**October 27, 2010
DRB Comments**

PROJECT # 1008558

APPLICATION # 10-70296

RE: Lot 146, Mirador Sandias & Lot 122, Cottonwood Hills

**Plat of
Lot 146-A-P1, Mirador Sandias
Subdivision, Seven-Bar Ranch and
Lot 122-A-P1, Cottonwood Hills
Subdivision, Seven-Bar Ranch**

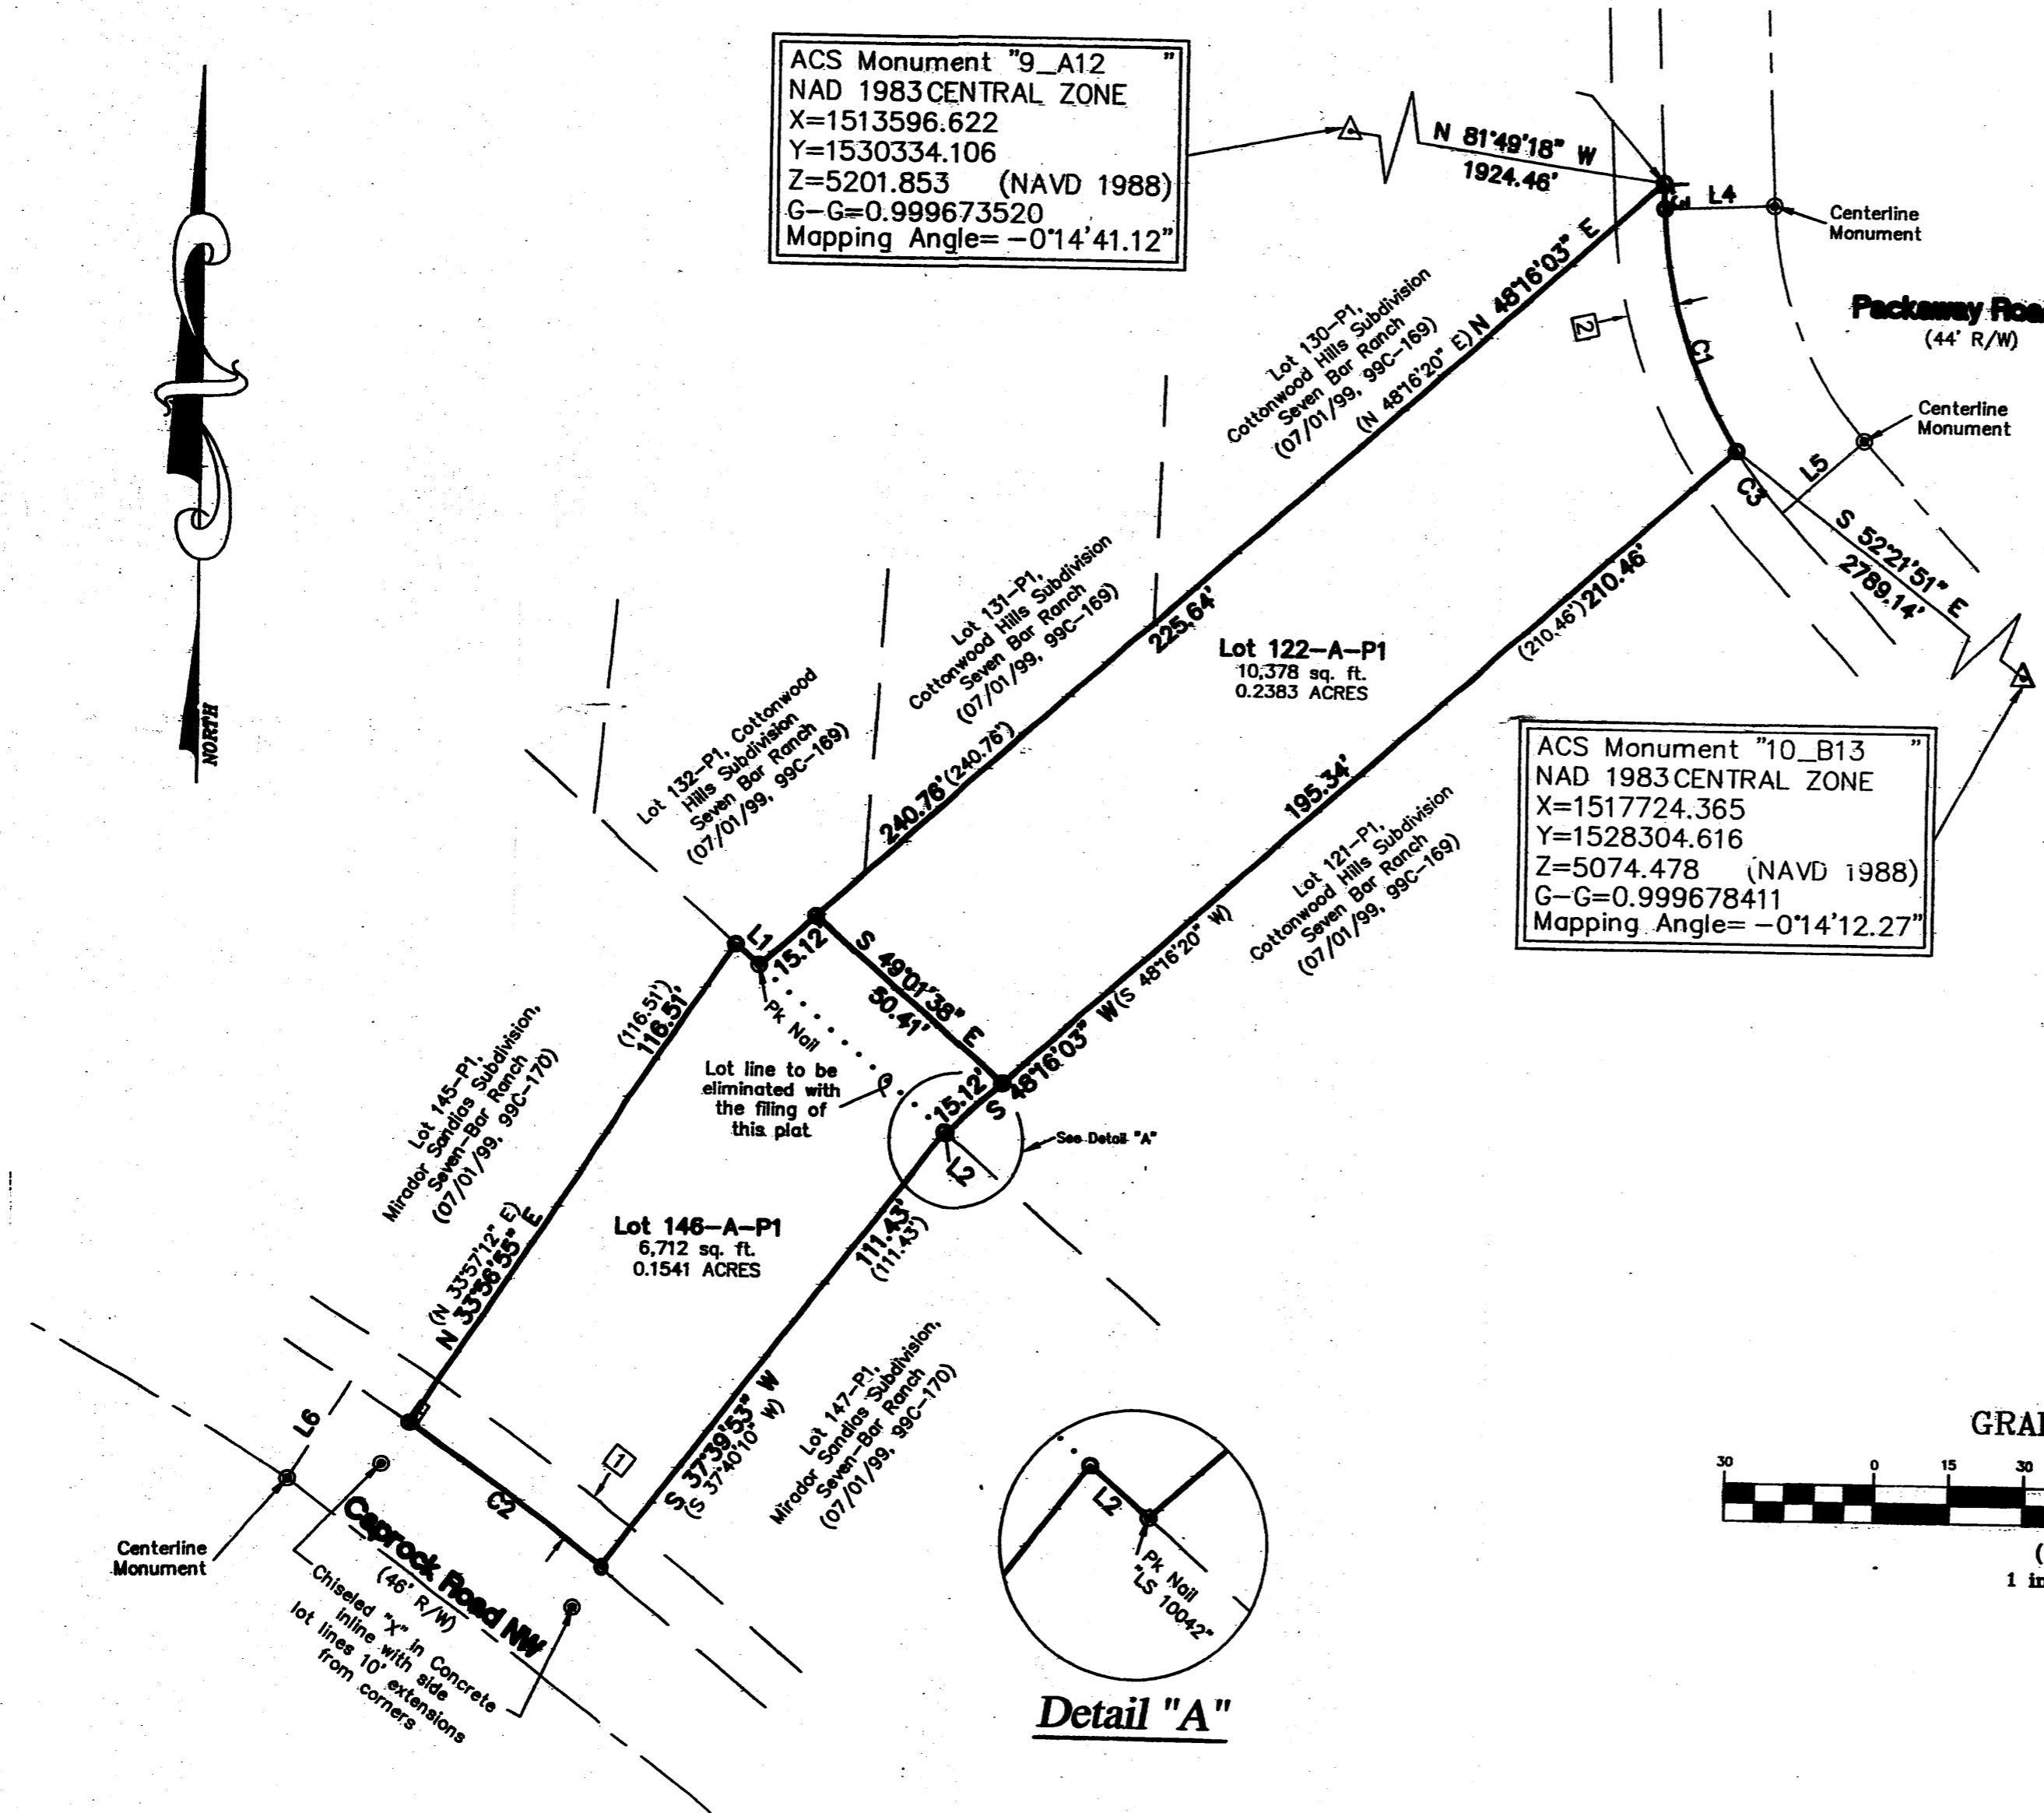
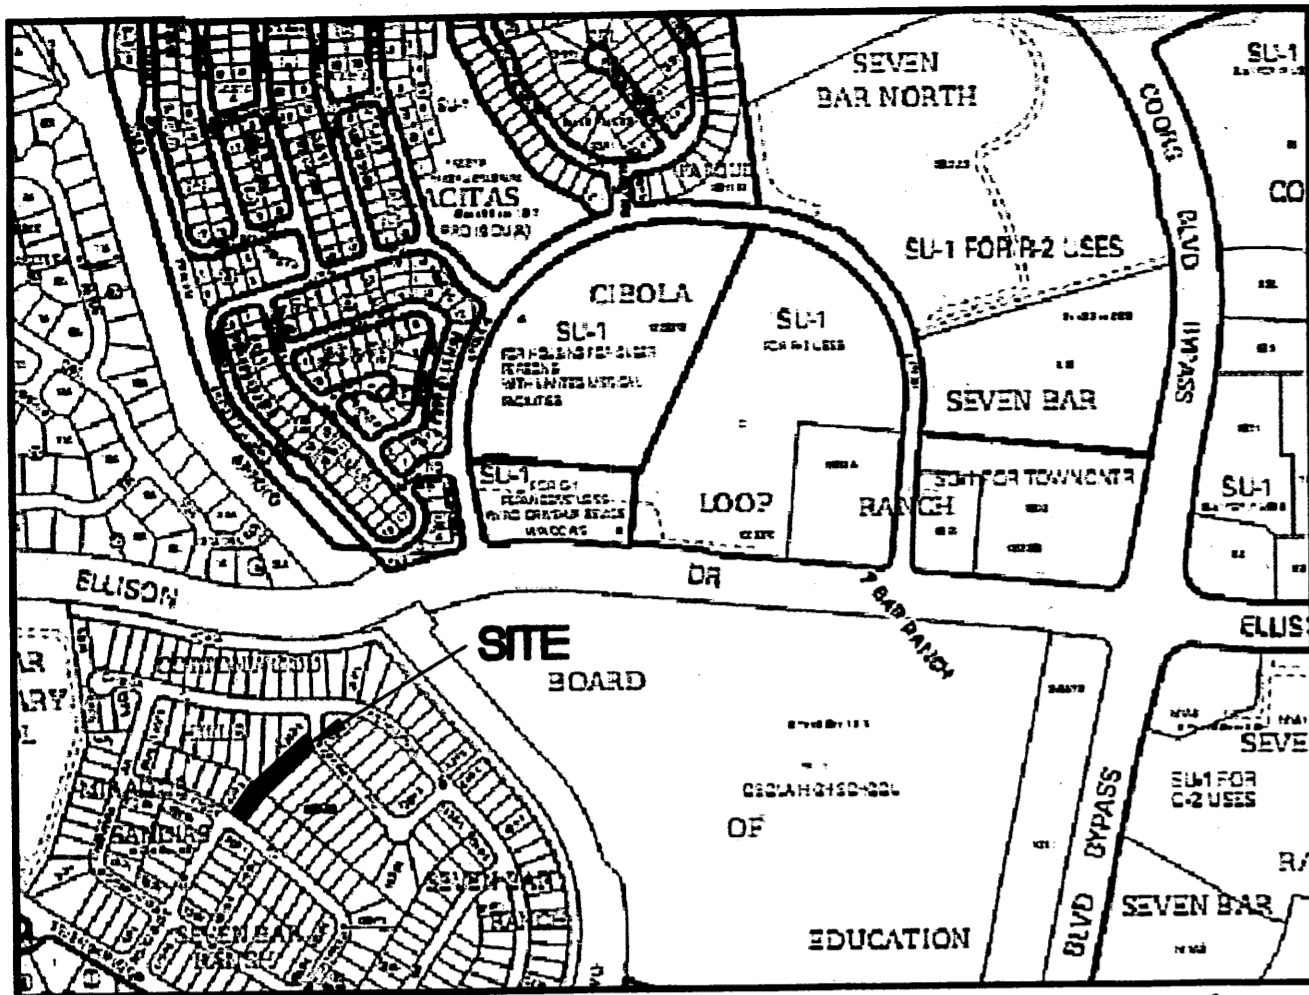
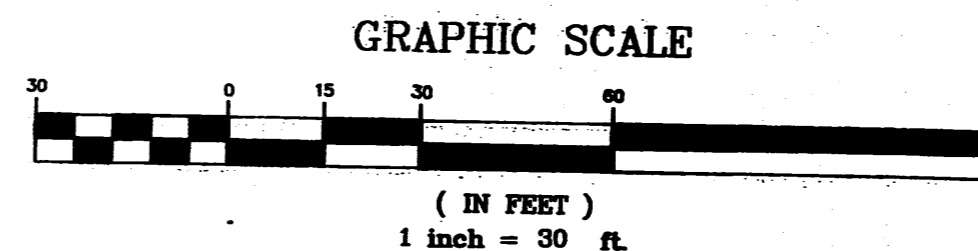
A solar access note consistent with § 14-14-4-7 of the Subdivision Ordinance needs to be on the plat.

Franchised utility companies need to sign-off on the plat or acknowledge their approval of the plat in writing. AGIS needs to approve the .dxf file prior to Planning sign-off.
